Subject: Planning Consultation on: WA/18/26/PL

Response to Planning Application

Application ref: WA/18/26/PL

Location: Land off Arundel Road Fontwell BN18 0SD

Drawing Title
Block Plan

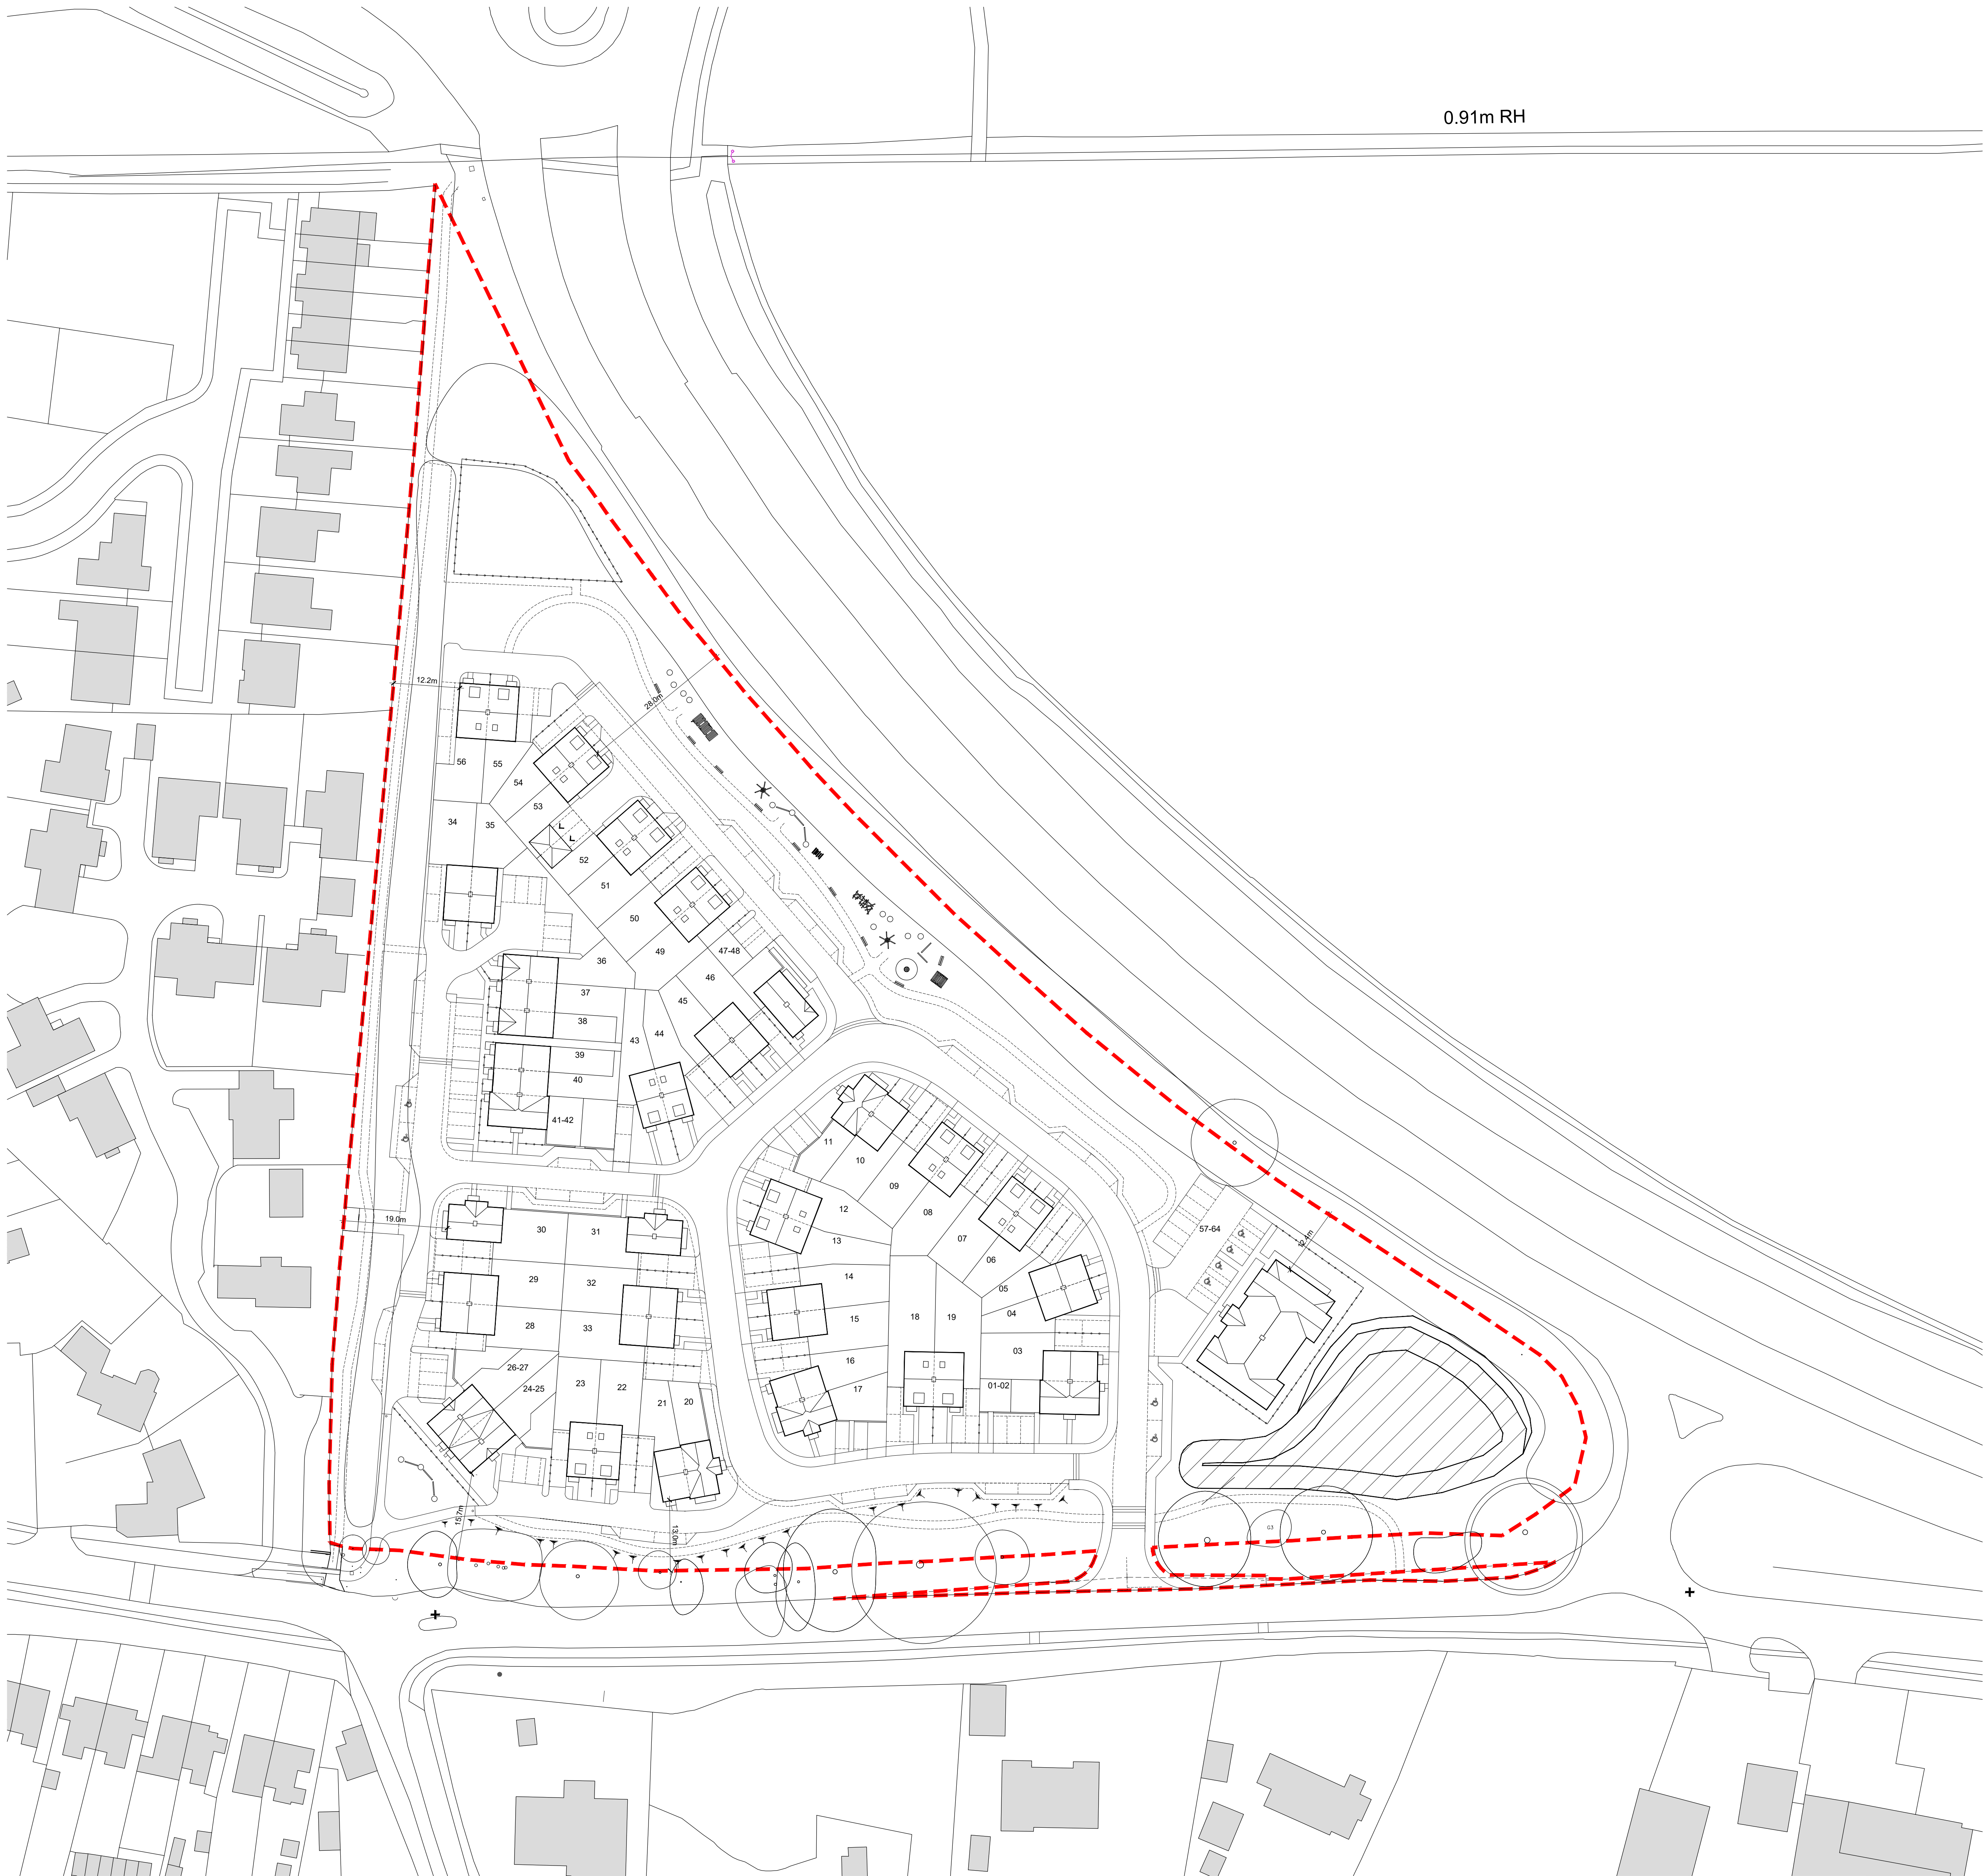
The areas of Public Open Space have been shown predominantly to the perimeter of the site with the largest area shown to the northern fringe of the proposals. The LEAP provision is shown to be located in this northern area which whilst would appear to offer the largest space to accommodate

this, it would subject to limited surveillance from onlooking dwellings and a missed opportunity not to be more centrally located within the development. There is no detail at this stage as to the content of the LEAP proposals but these need to include inclusive and accessible play features with a bespoke element providing a challenging and exciting play offer for this development. Dwg POS/PLAY SKE details the area only and also only shows one entrance/exit pathway where two would be a requirement. Pathways need also be all weather accessible of bound surface finish such as macadam. Additional Play as you go has been indicated along the eastern fringe POS which would be supported but needs to be further detailed. Further LAP provision is shown to the south/west corner of the site which would again require detail to be submitted and approved.

The retained vegetation with spatial buffer from the A27 as shown would be a valuable asset along the north-east boundary, however the allowance of some designated open space including the relocation of the LEAP with a good usable area of public open space to be distributed to the centre of the site would be a recommended amendment. The result would be a more accessible open space which would support a greater level of surveillance from surrounding dwellings.

The indicative layout shows the location of the proposed block of flats and adjacent SuDS provision, which appears close in proximity to the building structure. Trees and planting appear to be shown within the SuDS feature this would need clarification and be supported by Engineers dependant on form and policy. SuDS are required to be fitting with the development and well designed to be an asset to the site, to provide interest, visually and biodiversity enhancement. Tree species within SuDS features are not generally supported.

Pedestrian and cycle routes within the development should be a considered design features and their meaningful connection both within and beyond the site detailed. Pathways would need to be all weather accessible and be DDA compliant, it is unclear from the proposals what is proposed and how they link to the PRow.

SHEET 2 OF 2
PROPOSED PLAN,
INCLUDING DRAINAGE;
INDICATING TREE
PROTECTION MEASURES

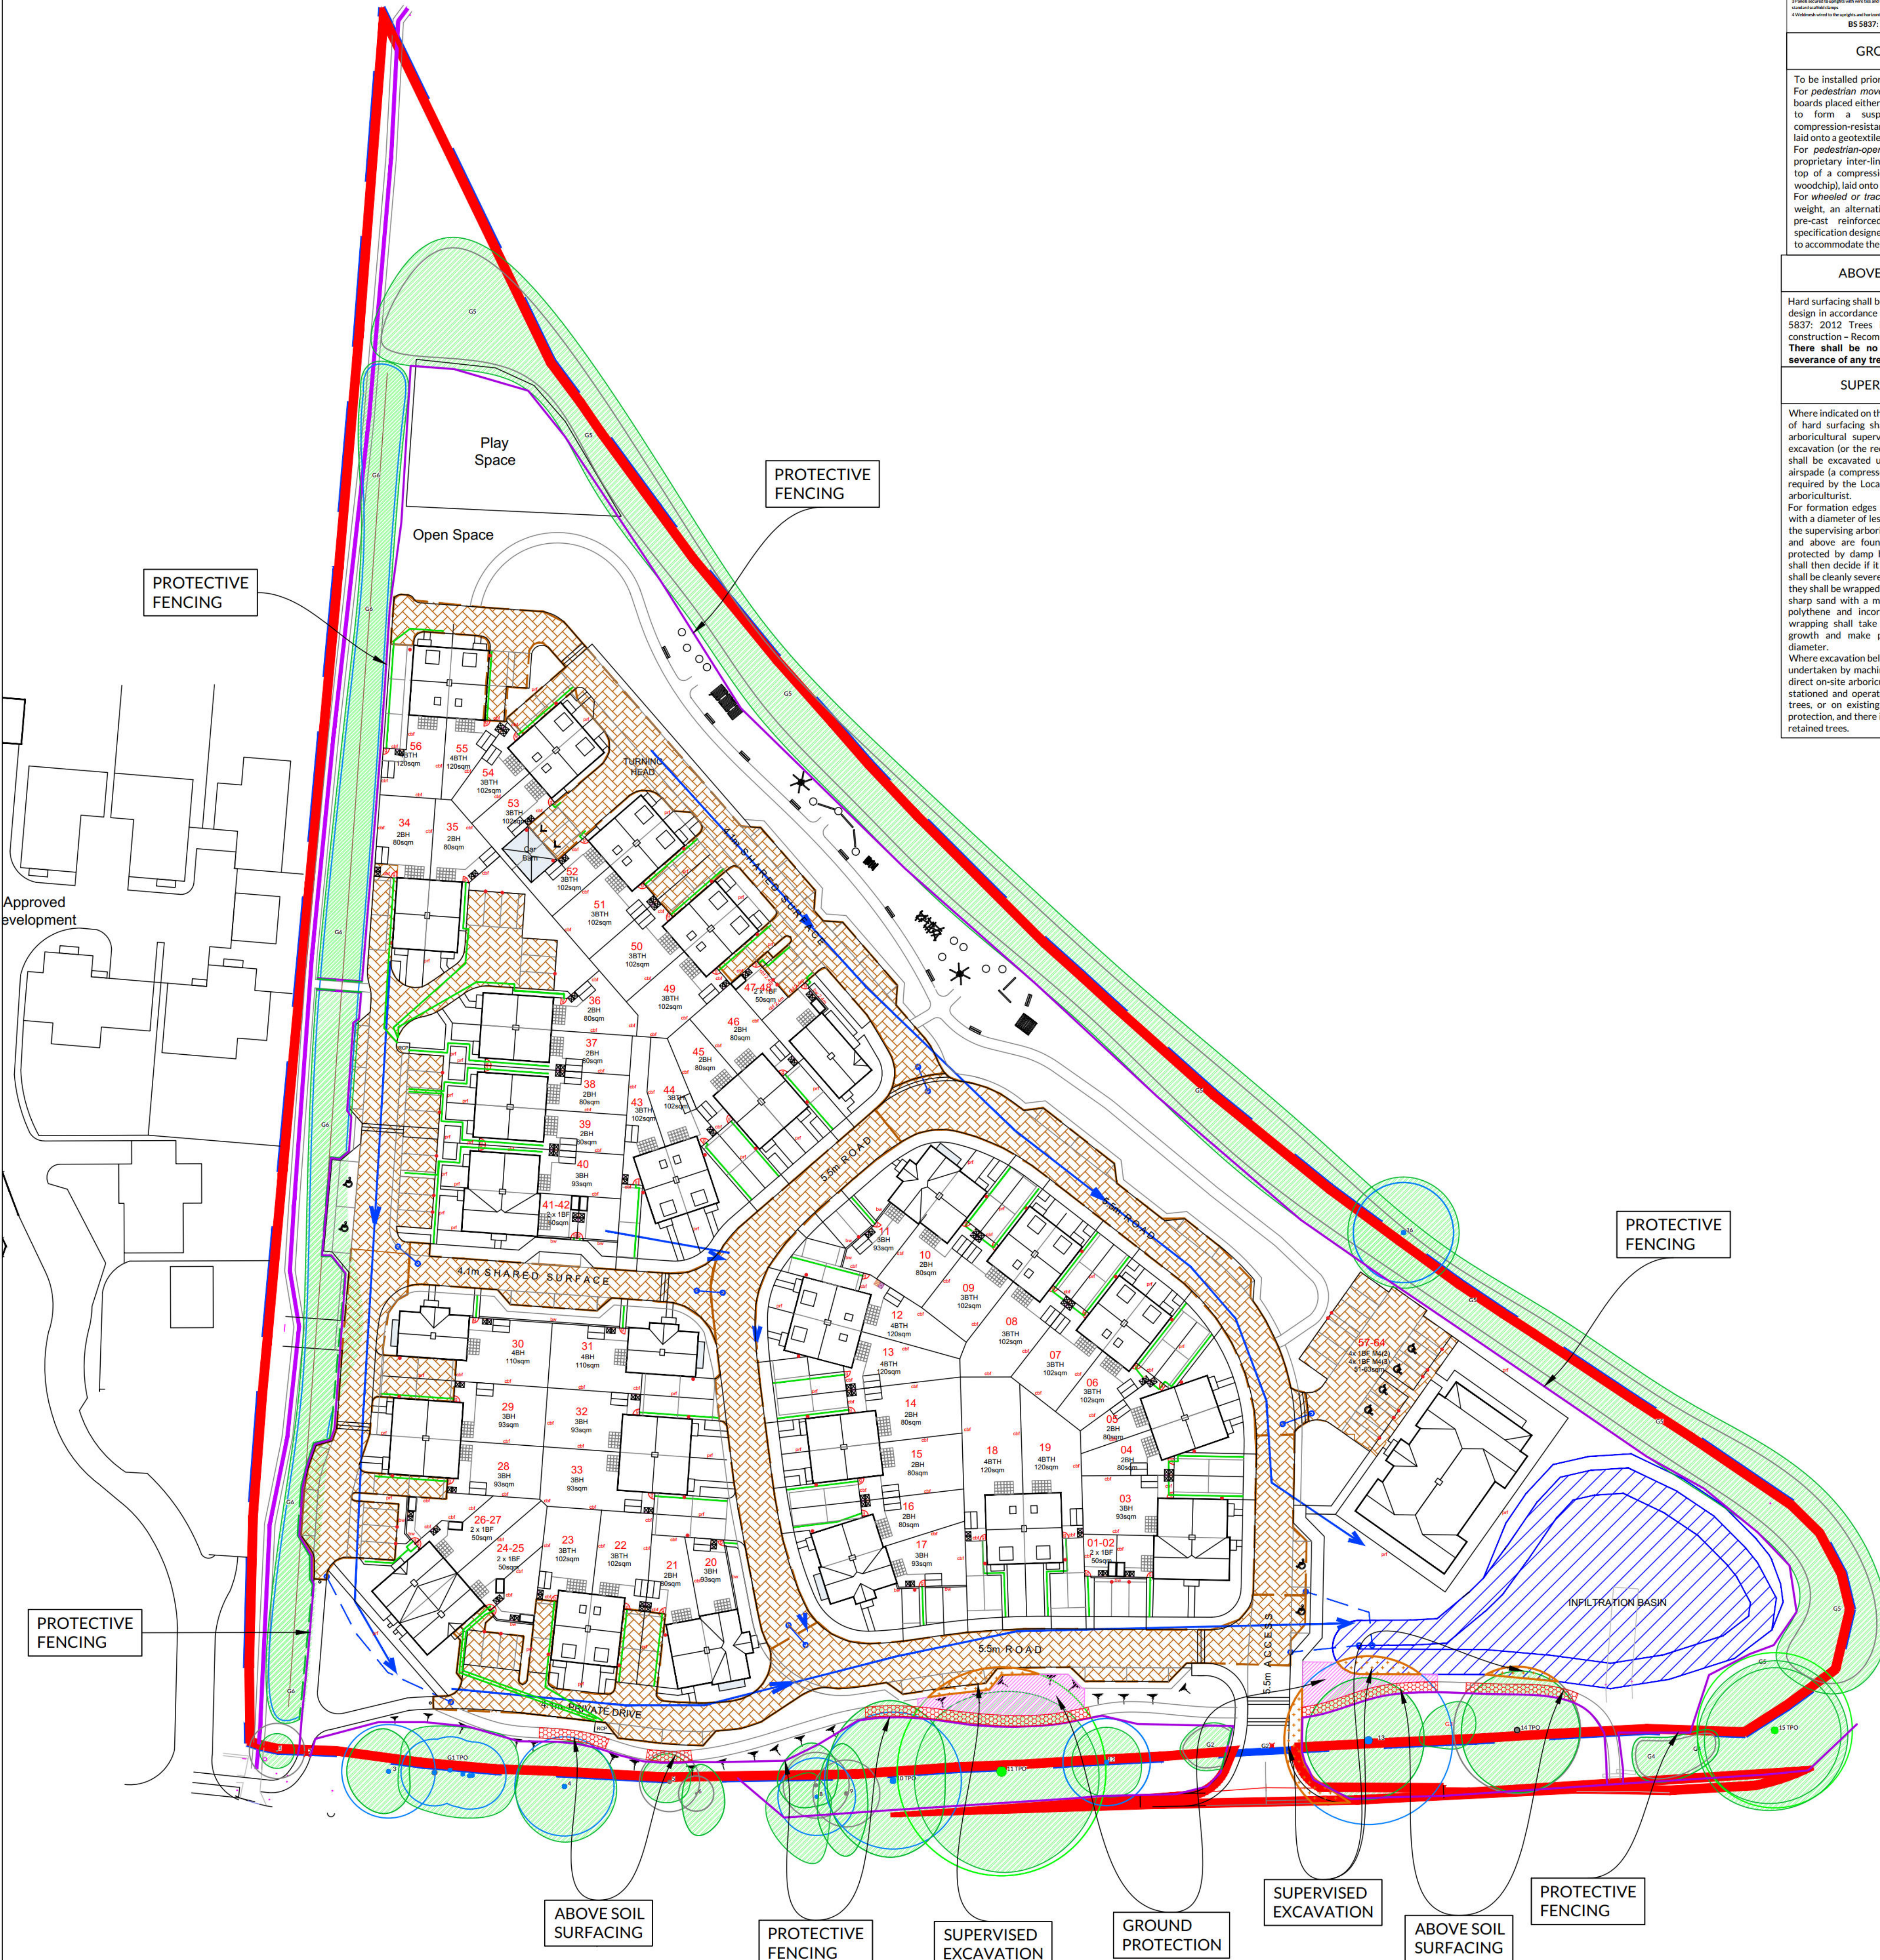
Trees of considerable landscape and ecological value have already been identified for preservation (TPO), throughout the southern boundary. It is vital that they are incorporated into either open space/landscape buffer zone, and any shared surface or other infrastructure remains outside of their root protection areas. Several are of potential veteran status. All should benefit from root protection area (plus a 2m buffer) as an absolute minimum requirement. This will ensure they are as remote from any development such that they can project veteran status without being spoilt by risk of mitigation pruning works.
